Interlaken Engineering and Design, PLLC  
7001 Seaview Ave NW, Suite 160-388  
Seattle, WA 98117 | (206) 470-9572

C1
 TESC/ Demo/ CSWPPP
 Scale: 1" = 10'

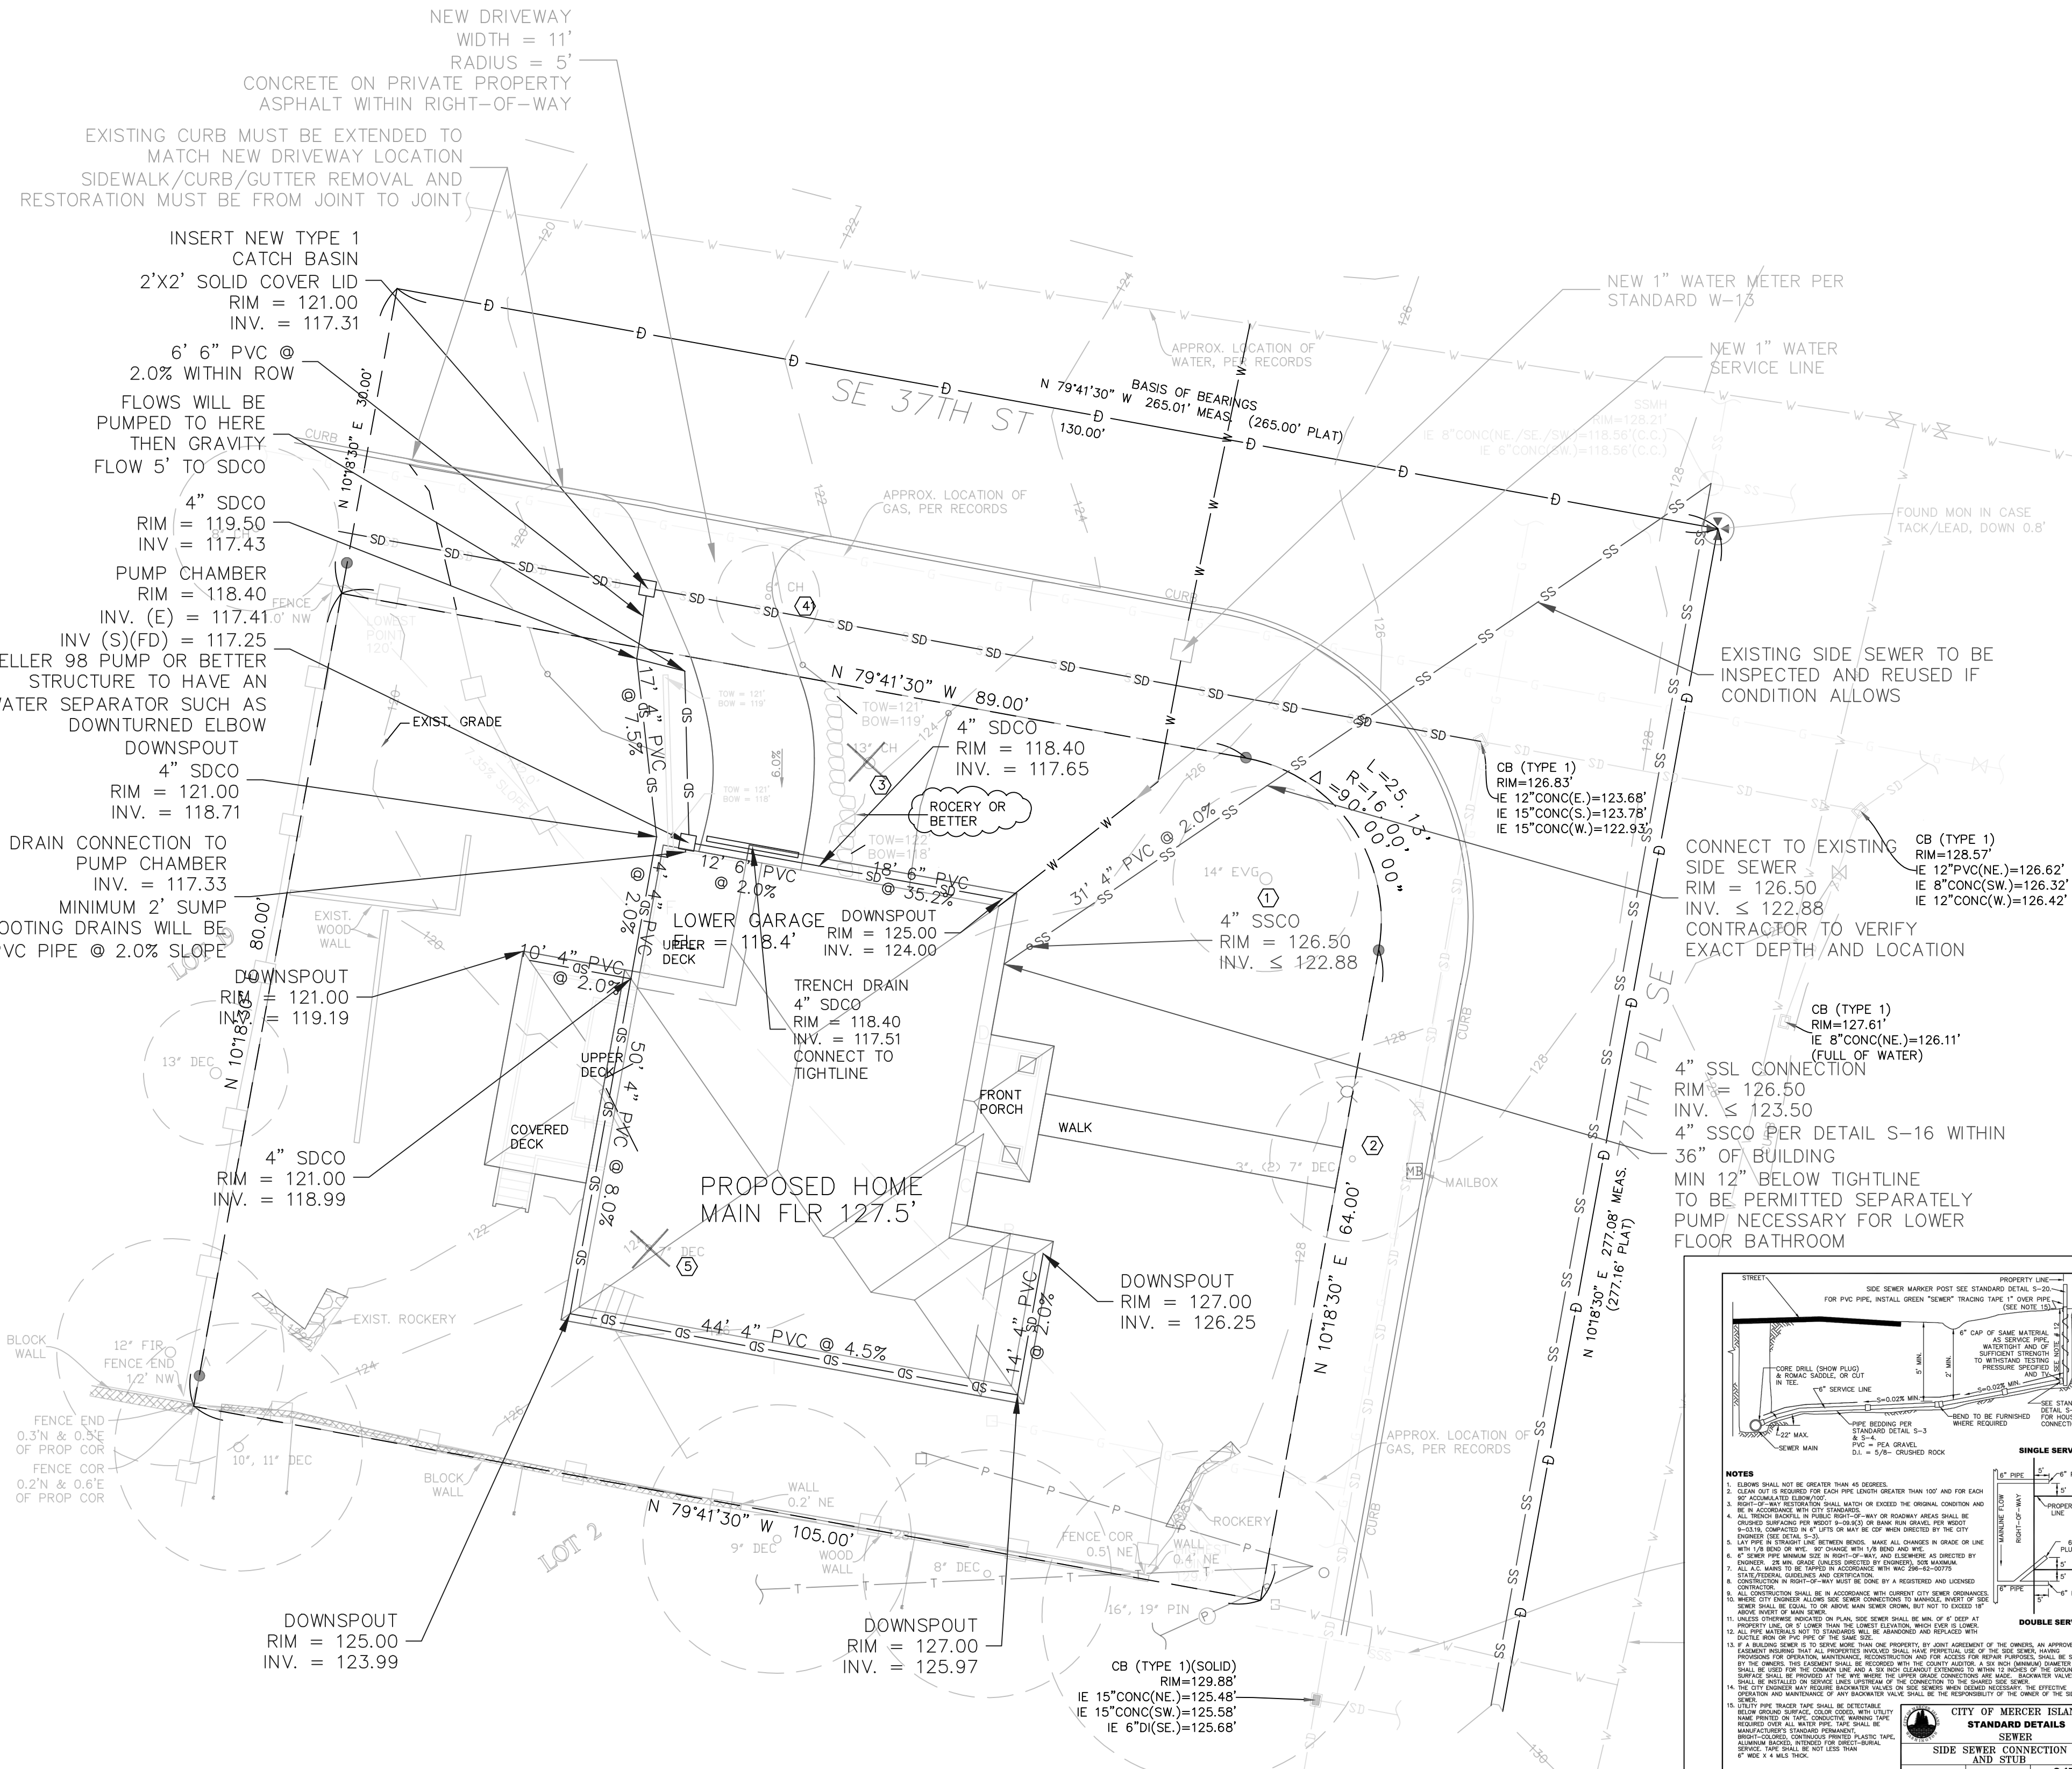
2. Indicate on the plan the driveway pavement type on private property and within ROW. Concrete and pavers are not allowed within City ROW.

3. The new driveway is shifting to the east of the existing location. The existing curbs must be extended/cut to match the new driveway location. Provide design and note stating the sidewalk/curb/gutter removal and restoration must be from joint to joint.

4. The storm outfall to the City storm system must connect to a new/existing CB. If new, specify the structure/lid size/type, rim, and inverts.

5. Provide design showing driveway area draining to the storm structure and specify an oil/water separator such as a tee or down-turned elbow.

6. Fire requires a 13d sprinkler system which will need a 1" water service line, 1" water meter, and a 1.25" water supply line per standard W-13 - please show these on the plan. Show the new water meter here - 30' west of existing CB @ SW corner of intersection, 2' south of gas main. Water service line will tap into water main along SE 37th St.

7. Provide grading design such as showing the final contours, spot elevations, slope arrows, percent slope around the building and driveways to clarify how these areas will drain and to show sufficient storm pipe coverage (18" minimum cover over existing concrete storm main).

8. Side sewer design not shown. Please provide complete side sewer design and details including cleanout locations, IE's at the building point of connection and existing tie-in point of connection, pipe type/size/slope, etc.

9. Show footing drain layout from the point of connection at the building to the downstream point of connection. Provide their respective IEs, pipe type/size/slope.

*The plans have been updated to indicate concrete on private property and asphalt within the ROW*

*The proposed design and note has been added to the plans*

*A new type 1 catch basin is proposed. The rim, inverts and lid size have been specified on the plans as requested.*

*The driveway will be collected by a trench drain and routed to a pump chamber with a downturned elbow.*

*New water line and meter have shown in requested location*

*Grading and slope arrows have been provided for clarification*

*Side sewer design and details have been shown on the site plan*

*Footing drains will be connected to a pump chamber and pumped up to point of connection with new proposed catch basin. Pumped flows will gravity flow for 10' prior to entering the mainline.*
